STATE OF WASHINGTON
DEPARTMENT OF ECOLOGY

August 29, 2006

Thank you for the opportunity to comment on the pre-threshold determination for the Ranch on Swauk Creek rezone and preliminary plat into 14 lots, proposed by Ranch on Swauk Creek, LLC and Cle Elum Pines, LLC [P06-27]. We have reviewed the environmental checklist and have the following comment.

Conceptual Water Plan

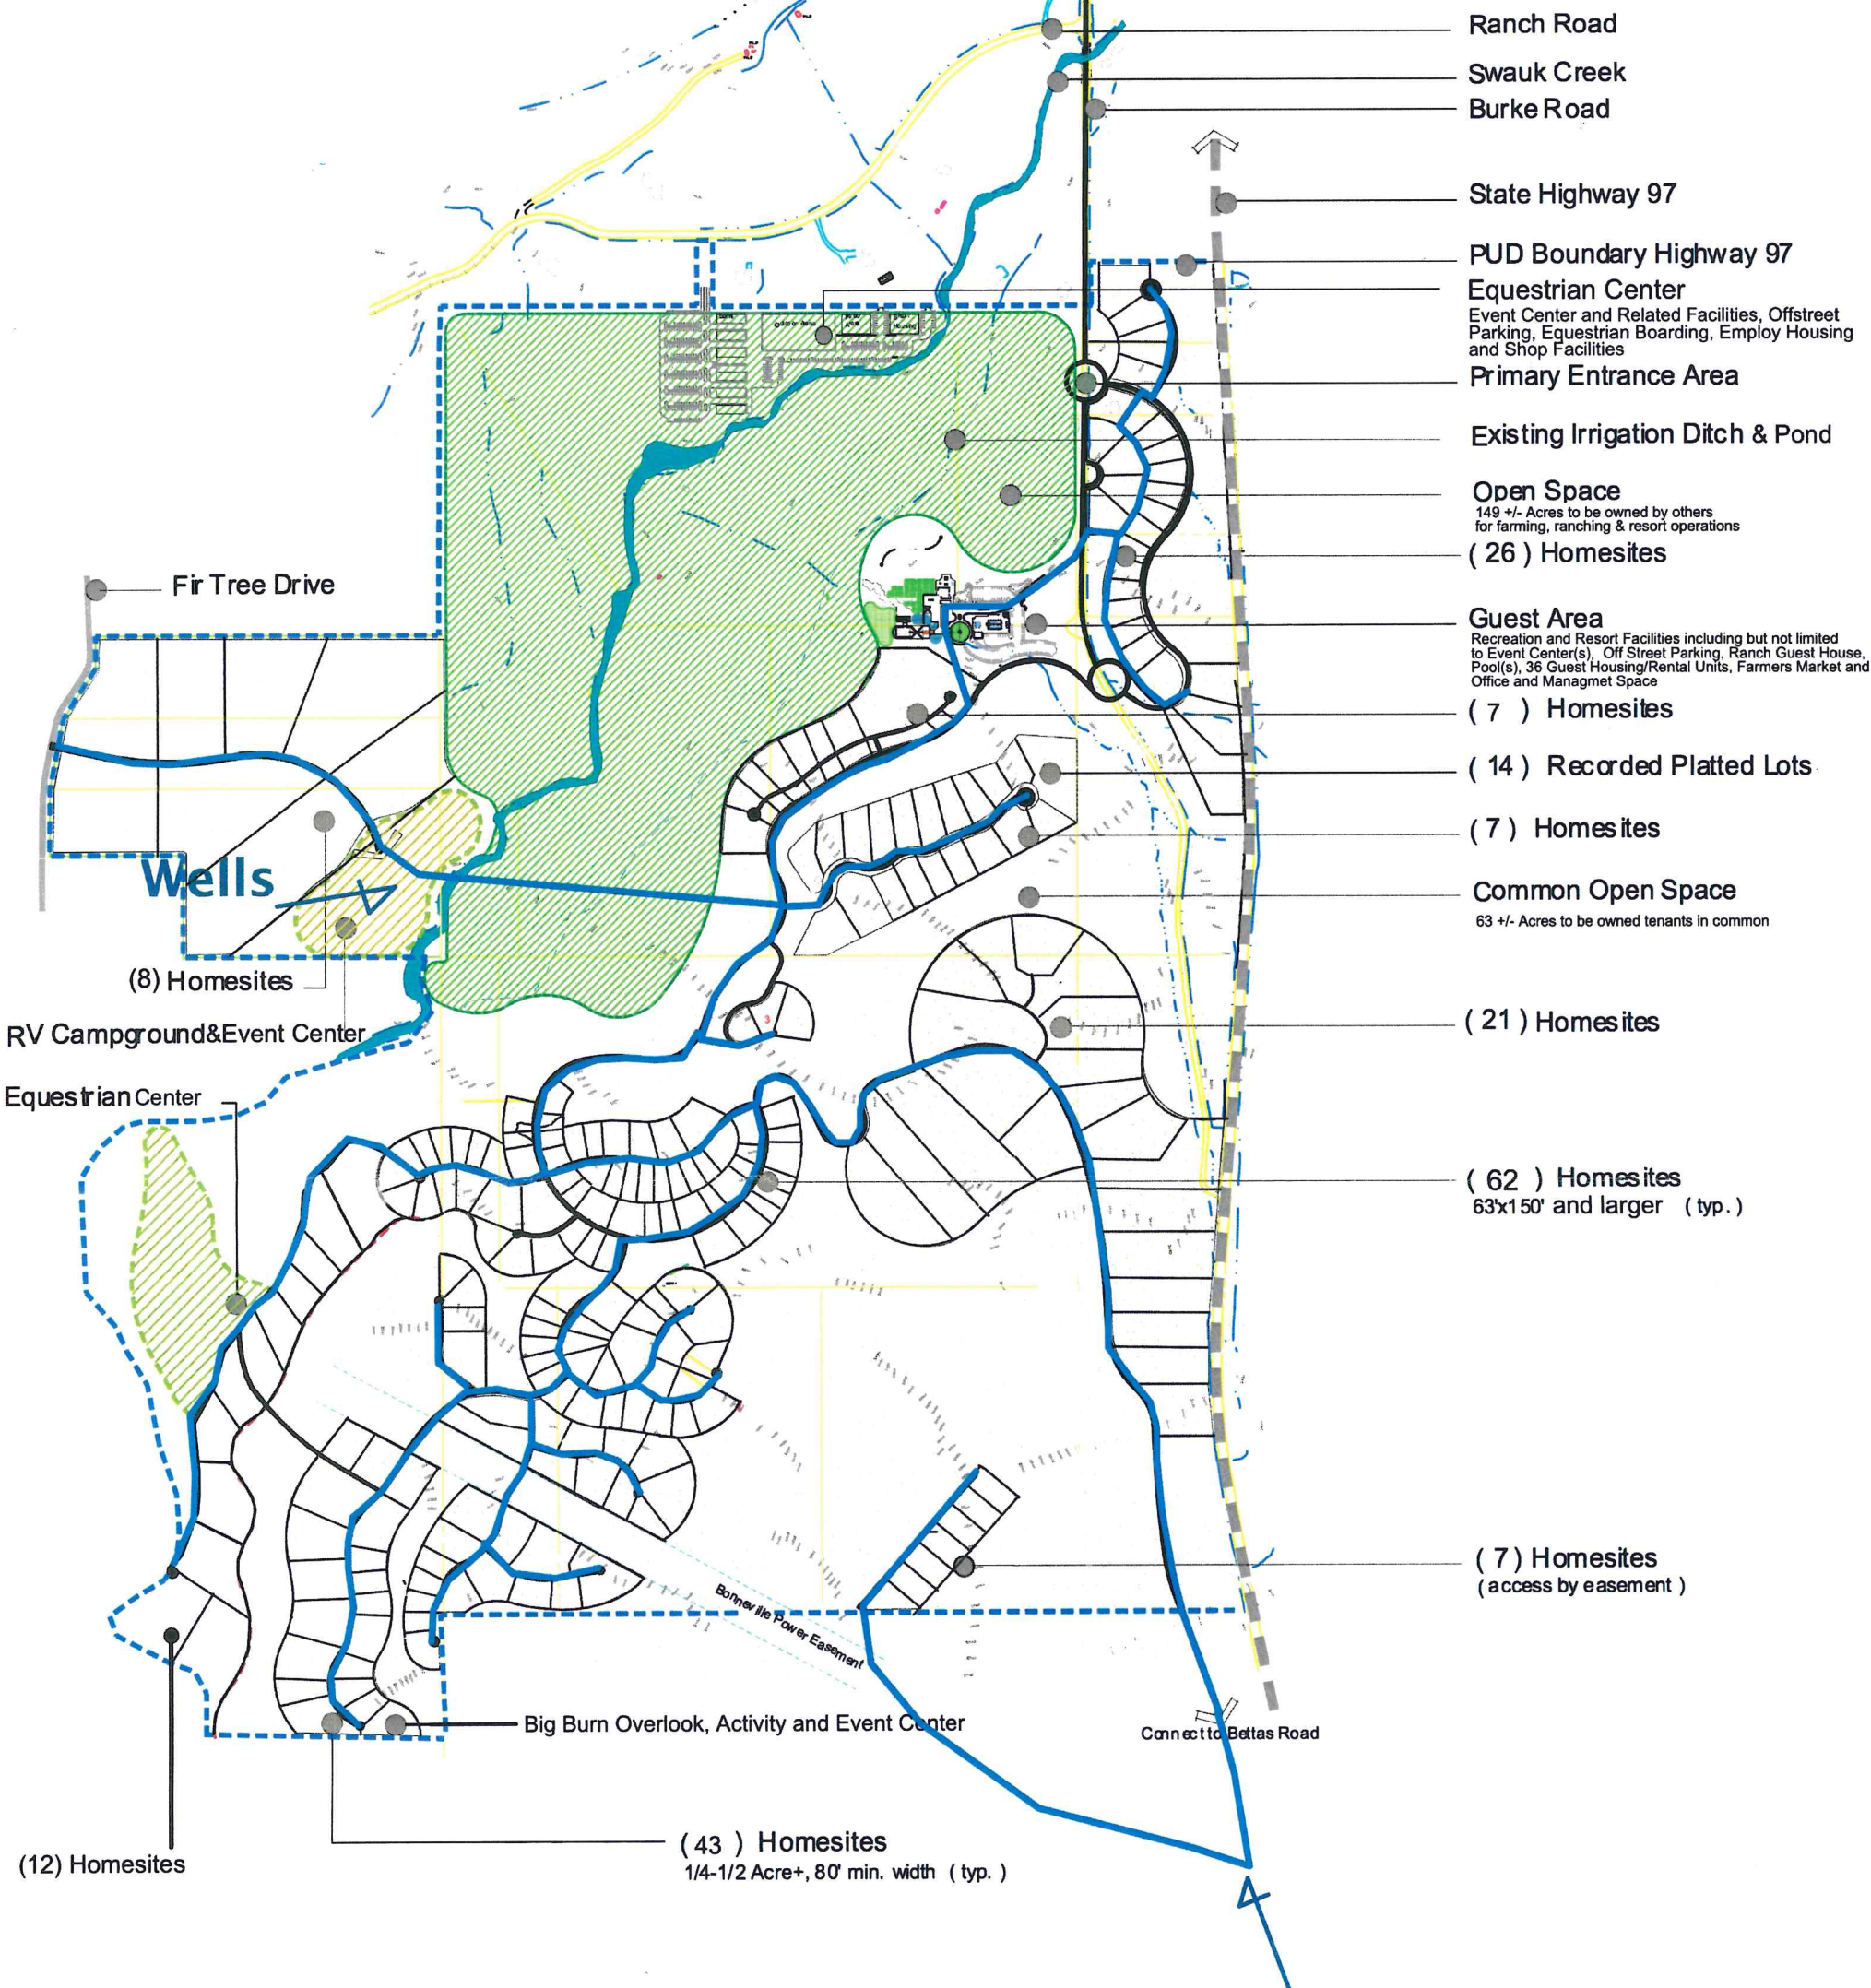
With the Supreme Court's guidance on the limitations of groundwater exemptions, all 14 lots would be covered by a single groundwater exemption. To comply with the 5,000 gallon per day limit, Ecology recommends metering the wells for this development. To comply with irrigating a total of 0.5 acres of lawn and garden, Ecology recommends requiring property covenants for each lot to limit the amount of the lawn and garden to be irrigated so it adds up to the maximum allowable acreage.

The proposed initial **14 lots** may not be classified as a Group B water system if 25 or more people are being served. It is likely that over 25 people will live in this proposed development with 14 lots. Ecology recommends that the County coordinate with the Washington State Department of Health on the requirements of a Group A water system, which will include water conservation requirements, an operators certificate, a water system plan, and other elements.

To comply with the 5,000 gallon per day limit, Ecology recommends metering the wells for this development. To comply with irrigating up to 0.5 acres of lawn, Ecology recommends requiring

property covenants for each lot to limit the amount of the lawn and garden to be irrigated so it adds up to the maximum allowable acreage.

The build-out of 243 lots for this project will require a Group A water System. The applicants refer to being incorporated into the Hidden Valley Water System and applying Senior Water Rights to the project. Any change in water use for existing water rights will require an *Application for Change* with the Department of Ecology. Hidden Valley Water System would also need to be changed to incorporate the new development. The Hidden Valley Water System plan from 2002 only lists one junior surface water right (Court Claim No. 01146 for Bruce Coe). The Yakima River Basin Adjudication Court (Ecology vs. Acquavella No. 77-2-01484-5) issued an Order, Court Docket No. 18638 which in part states that post 1905 water right holders are ordered to cease all diversions while the pro-ratable user receives less than its full entitlement. The Hidden Valley Ranch community domestic right has a priority date junior to the May 10, 1905 pro-ratable water rights.
